Re: Objection to Planning Application 2026/90930 – 349 Whitehall Road, Wyke, BD12 9DP

I wish to formally object to planning application 2026/90930 relating to the demolition of the existing garage and erection of single storey side and two storey side and rear extensions with dormer windows at 349 Whitehall Road, Wyke, BD12 9DP, as detailed on the submitted plans.

Proposed Other Side Elevation
Scale 1:50@A1

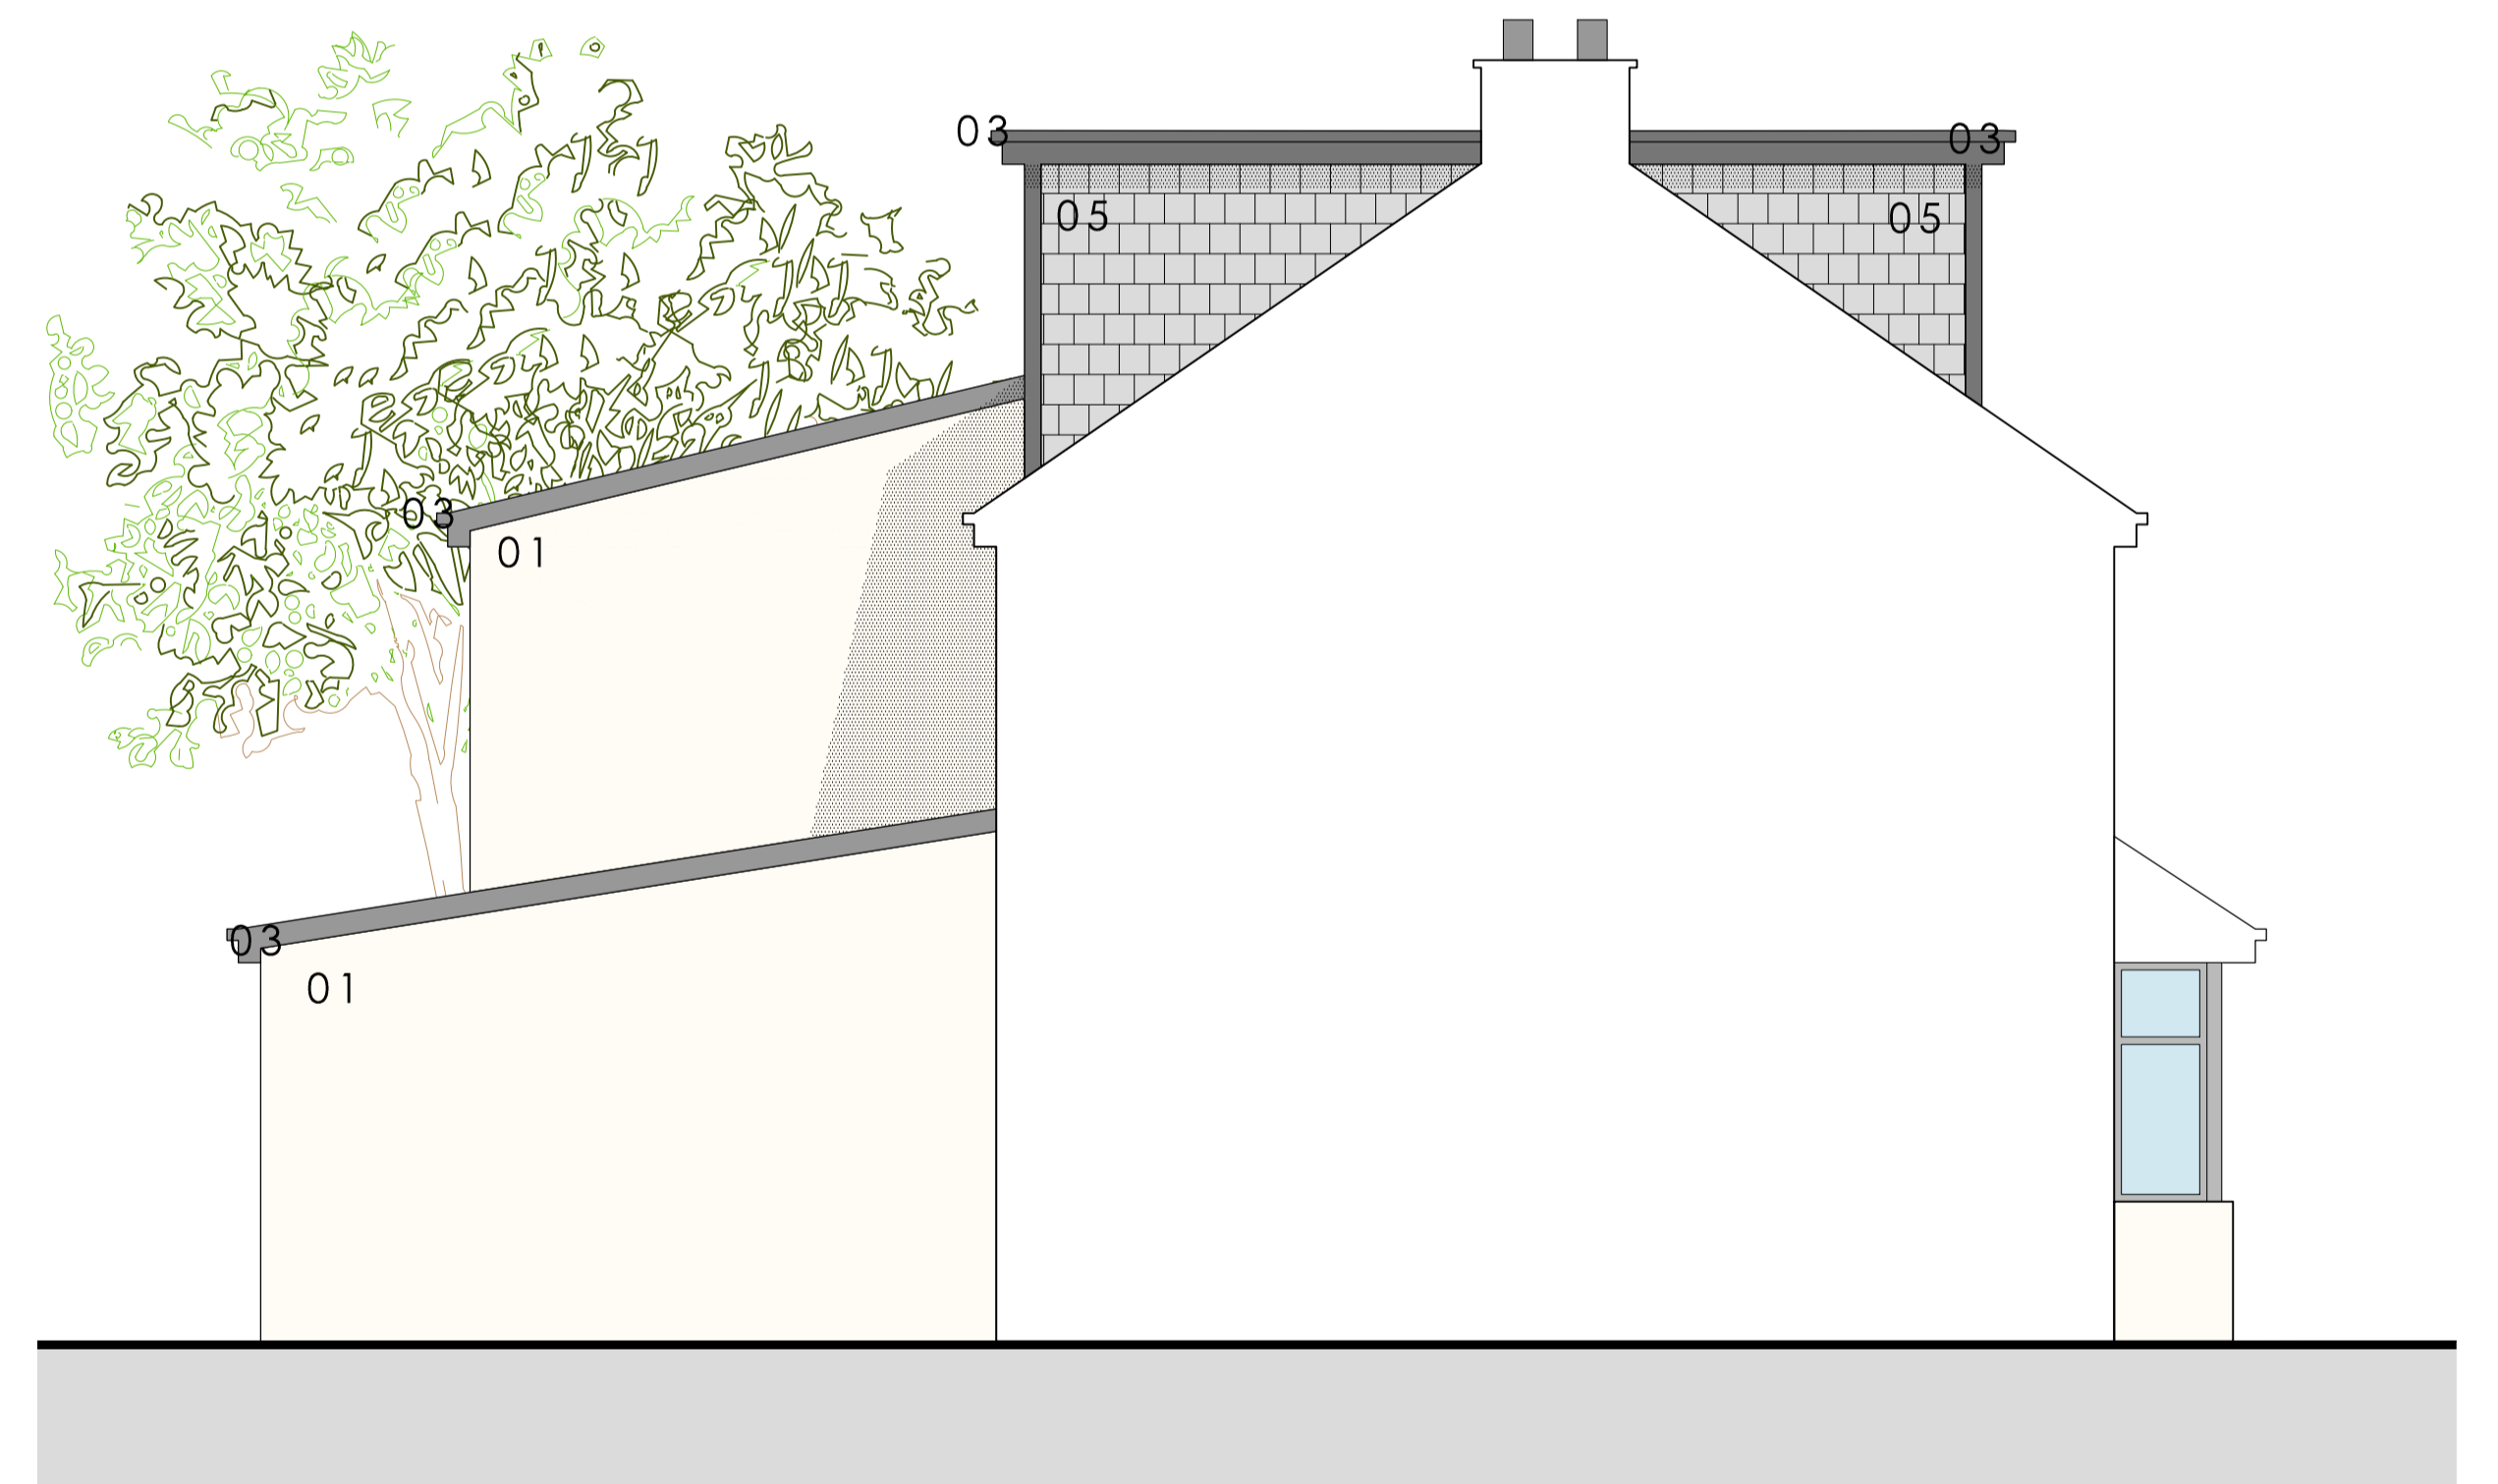
The proposed two-storey side and rear extensions substantially increase the height and depth of the built form close to neighbouring boundaries. The enlarged side elevation and rear projection shown on the submitted drawings raise serious concerns regarding overshadowing and reduction in daylight to adjoining habitable rooms, garden and outdoor amenity spaces.

The rear dormer appears excessively large and fails to appear subordinate to the existing roof form. Combined with the extensive side and rear additions, the proposal risks creating a property that is materially out of scale with neighbouring homes.
